ASSESSMENT REPORT

STAGE 1 OF MONTEFIORE AGED CARE FACILITY MP 10_0044 MOD 2

Figure 7: the top floor of the Concept Approval (left) and the modification including setbacks in response to FEAR 8 (right) (Base source: MP10_0188 MOD 2 and the modification application)

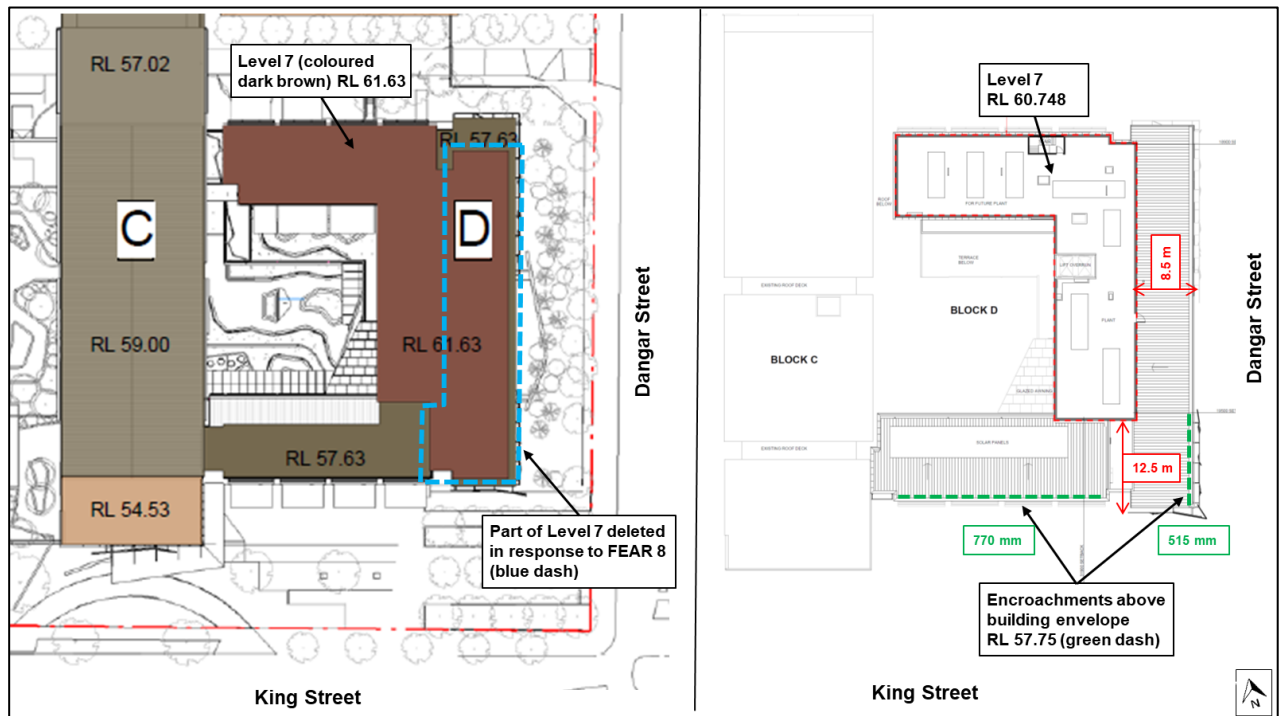
The top floor of Building D would have a maximum height of 60.748 m which is 1.78 m lower than the maximum height permitted under the Concept Plan. It will consist of plant which has been set back from the building edge so it would not be visible from the street, in accordance with the Concept Approval requirements (as shown at **Figure 7**).

The Department therefore considers the proposal is acceptable as it is consistent with ToA 6 and FEAR 8 and would not result in any unreasonable visual impacts.

Figure 7 – Façade detail at the corner of King Street/Dangar Street

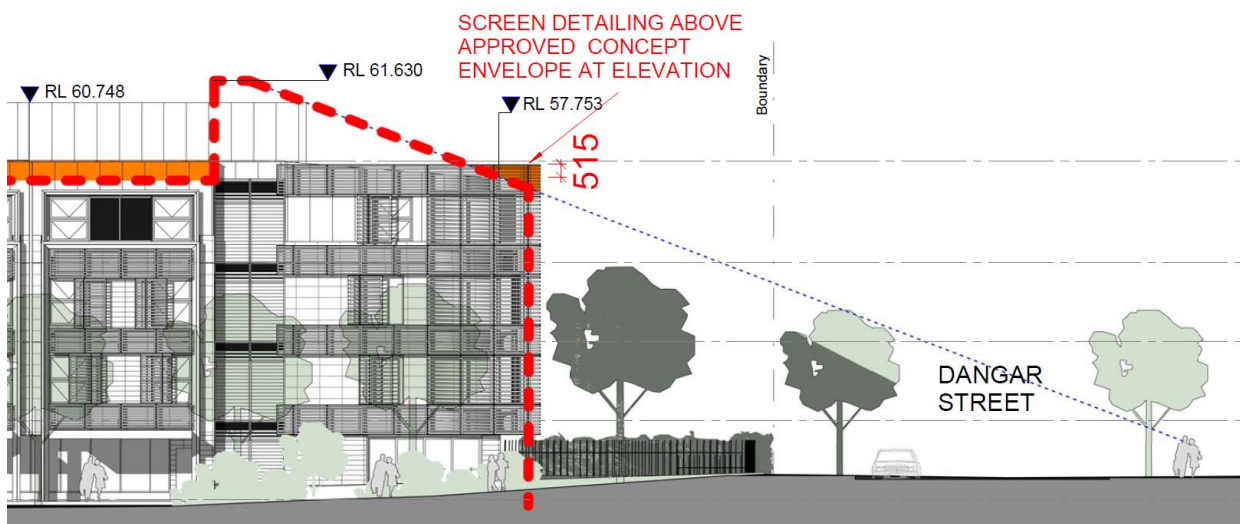
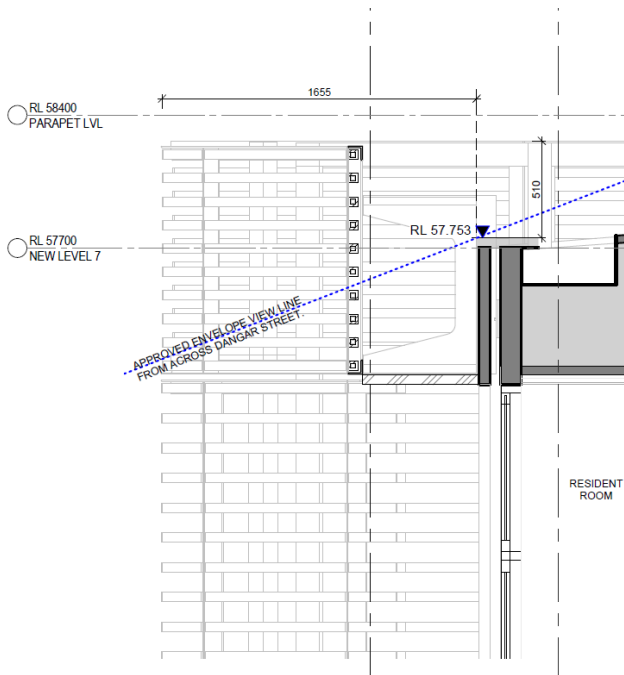
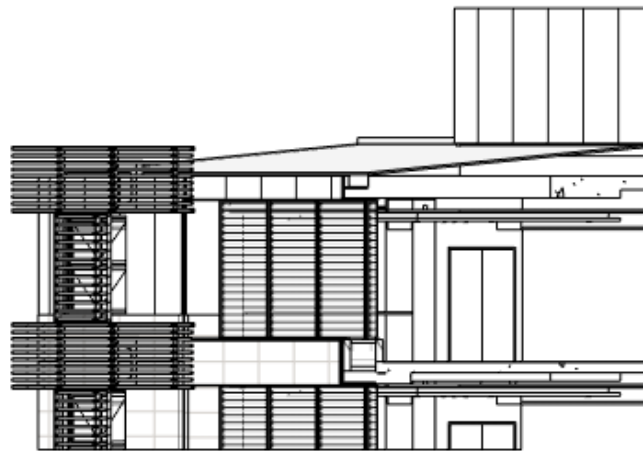
- 515 mm fronting Dangar Street, comprising a light weight architectural/façade screen
- 770 mm fronting King Street, comprising the building parapet.

Concern was raised in public submissions and by Council about the proposal exceeding the Concept Approval height at the building edge and the visual impact of the building.

The Department considers the 770 mm and 515 mm encroachments above the RL 57.75 height limit for the edge of Building D are acceptable as:

- the building is setback 19.5 m from King Street and 10 m from Dangar Street and when viewed from the street, the encroachments are minor and are unlikely to be noticed
- the proposed building edge heights are lower than the Project Approval building edge heights as shown at **Table 2**
- the architectural screen fronting Dangar Street is contained within a relatively small proportion of the overall facade
- the architectural screen and the metal parapet are lightweight constructions that are architecturally integrated into the overall design of the building.

The Proponent states the 770 mm height exceedance along the King Street frontage is below the maximum approved height of Building D (under the Concept Approval) and adjoining Building C and is minor in nature. The 515 mm exceedance along the Dangar Street frontage extends less than a third of the façade, is lower than the maximum building envelope height established by the Concept Approval (RL 61.63) and forms part of the architectural expression of the building.
